Submission by Mallard Pass Action Group (MPAG)

**Deadline 4:**

**ISH2 Environmental Matters**

**Written Summary of Oral case**

Drawing file: EN010127 / EN010127-000216-Figure 06.6_Zone of Theoretical Visibility Study Representative Viewpoint and Illustrative Viewpoints.pdf

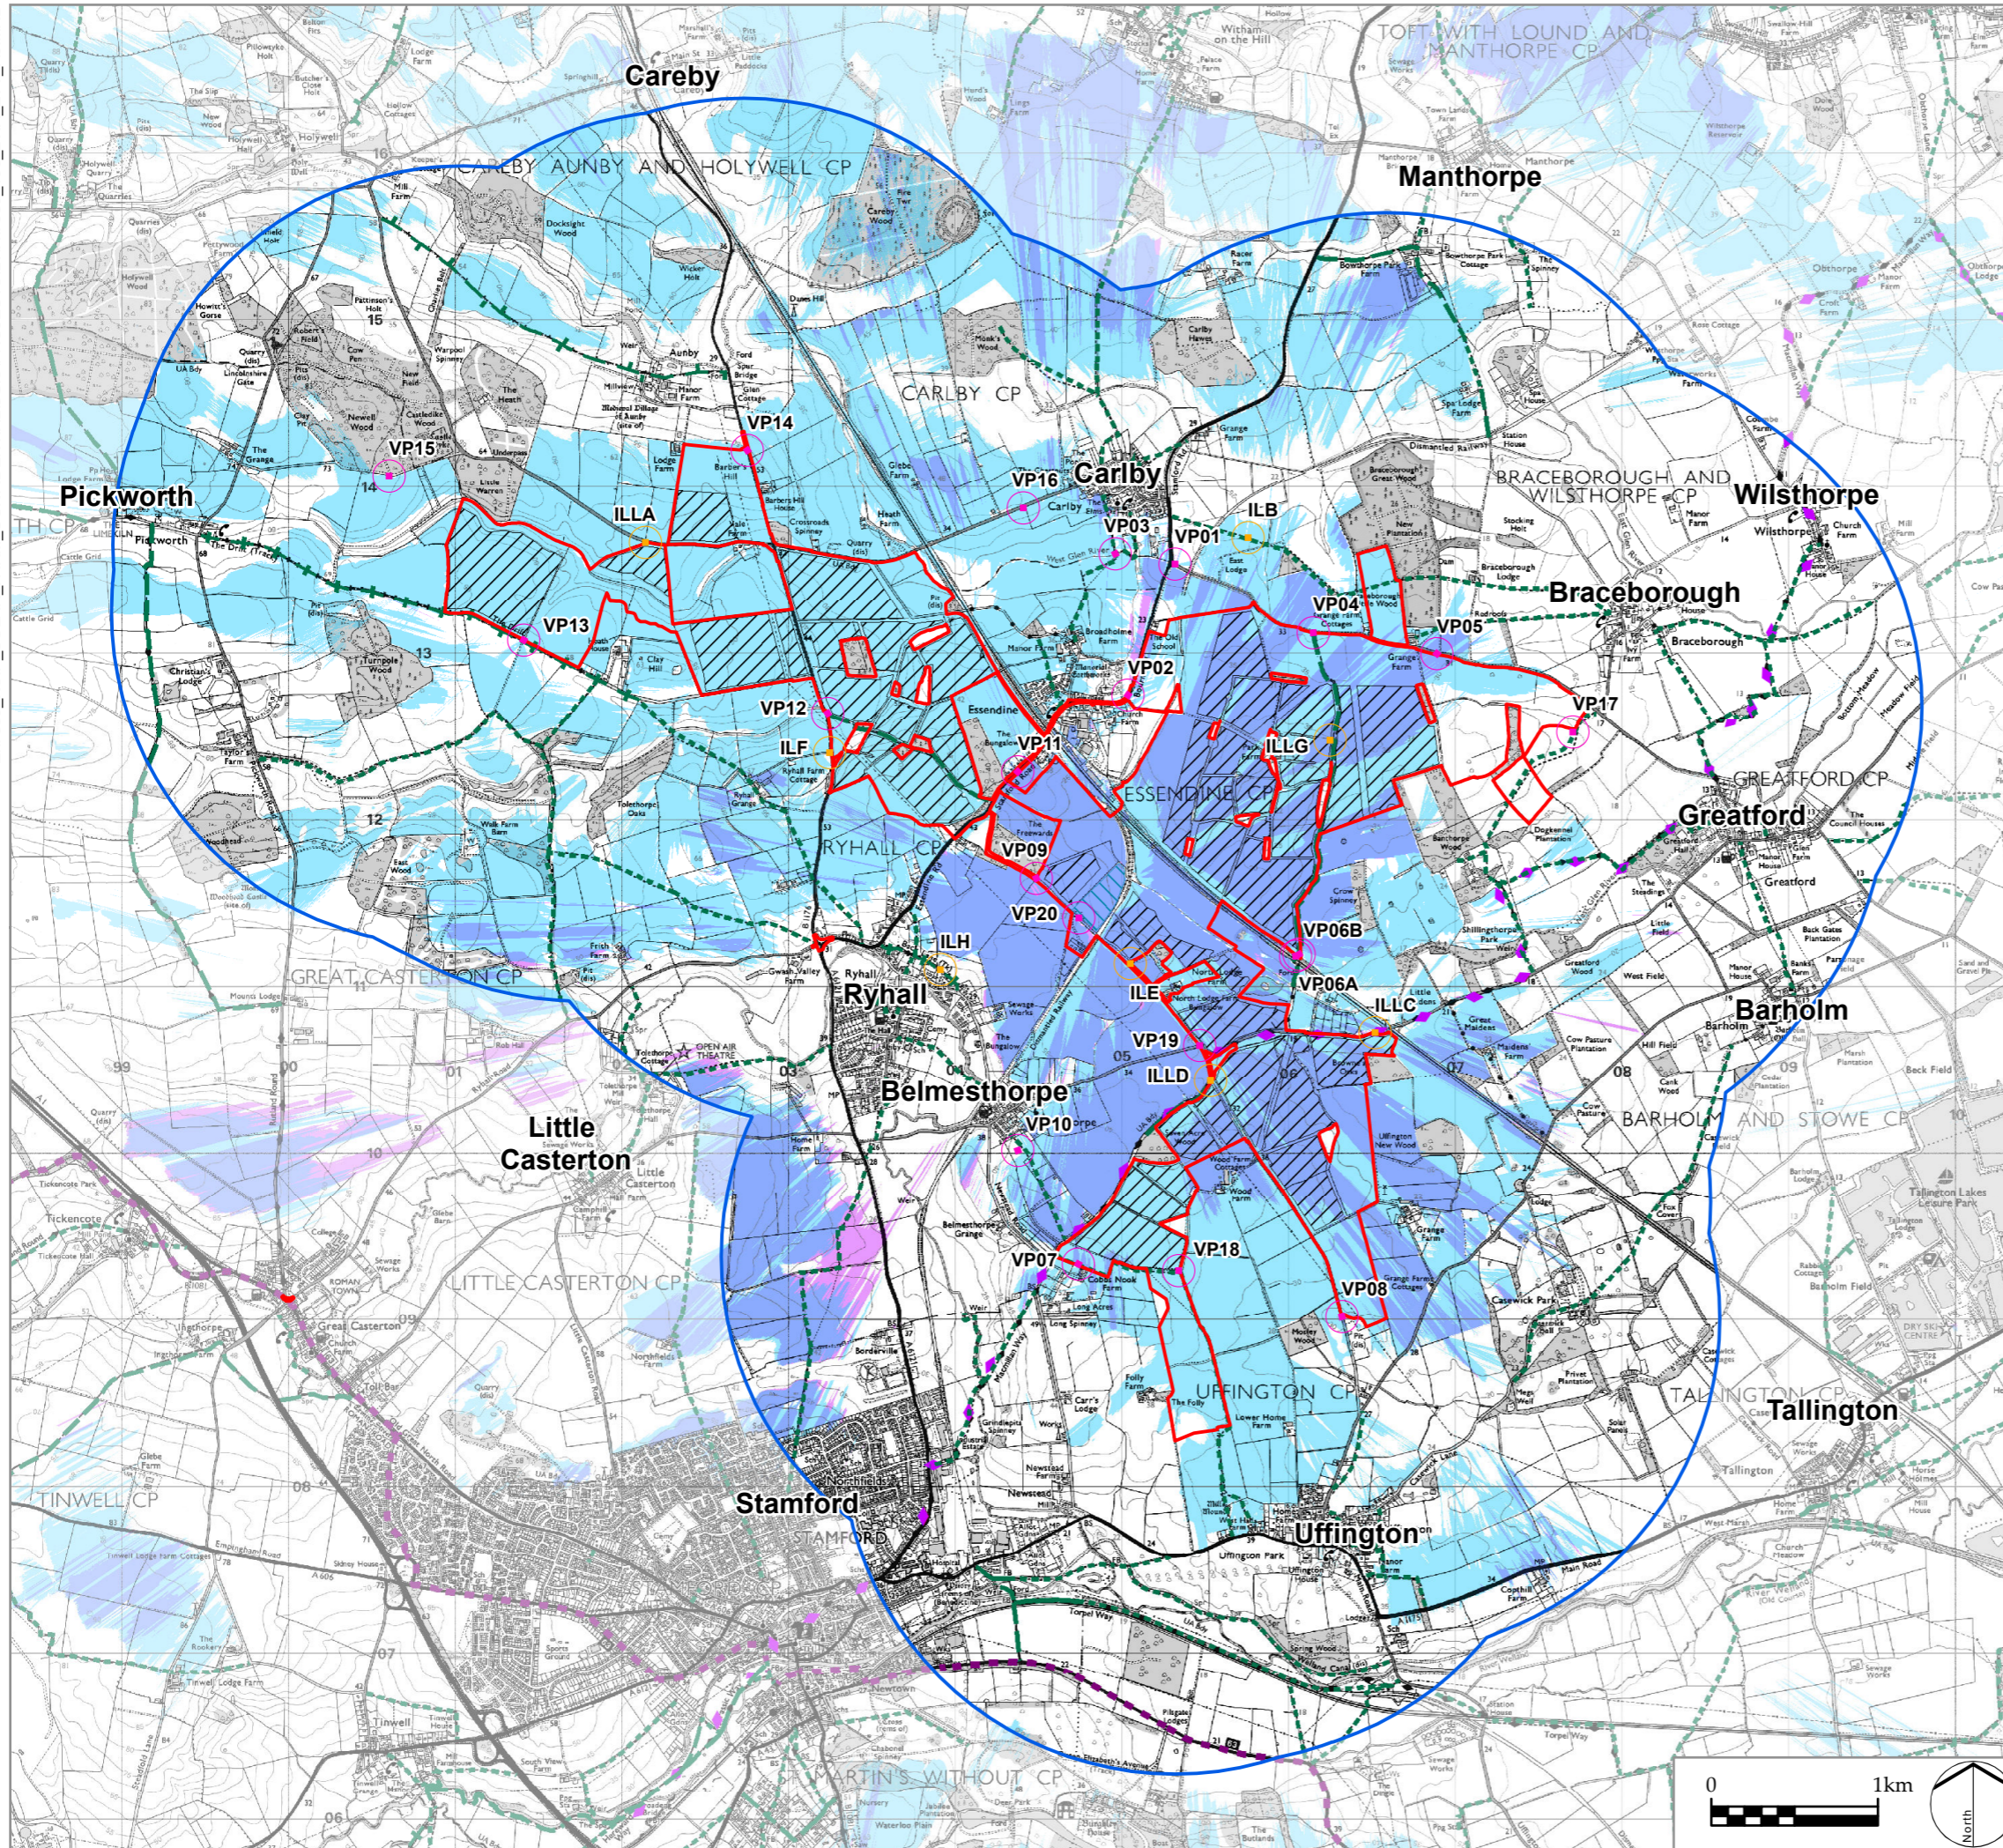
15. As it is based on topography, the Applicant's Zone of Theoretical Visibility (ZTV) plan (Figure 6.6: Zone of Theoretical Visibility (ZTV) Study Representative Viewpoints and Illustrative Viewpoints, doc. ref. EN010127-000216-Figure 06.6) is useful when assessing the extent of interinfluence, and judging how quickly / over what distance levels of landscape effects are likely to reduce from Major to Slight / No Change; however, the ZTV only shows intervisibility, and as explained above, effects on landscape character are not determined by visibility.
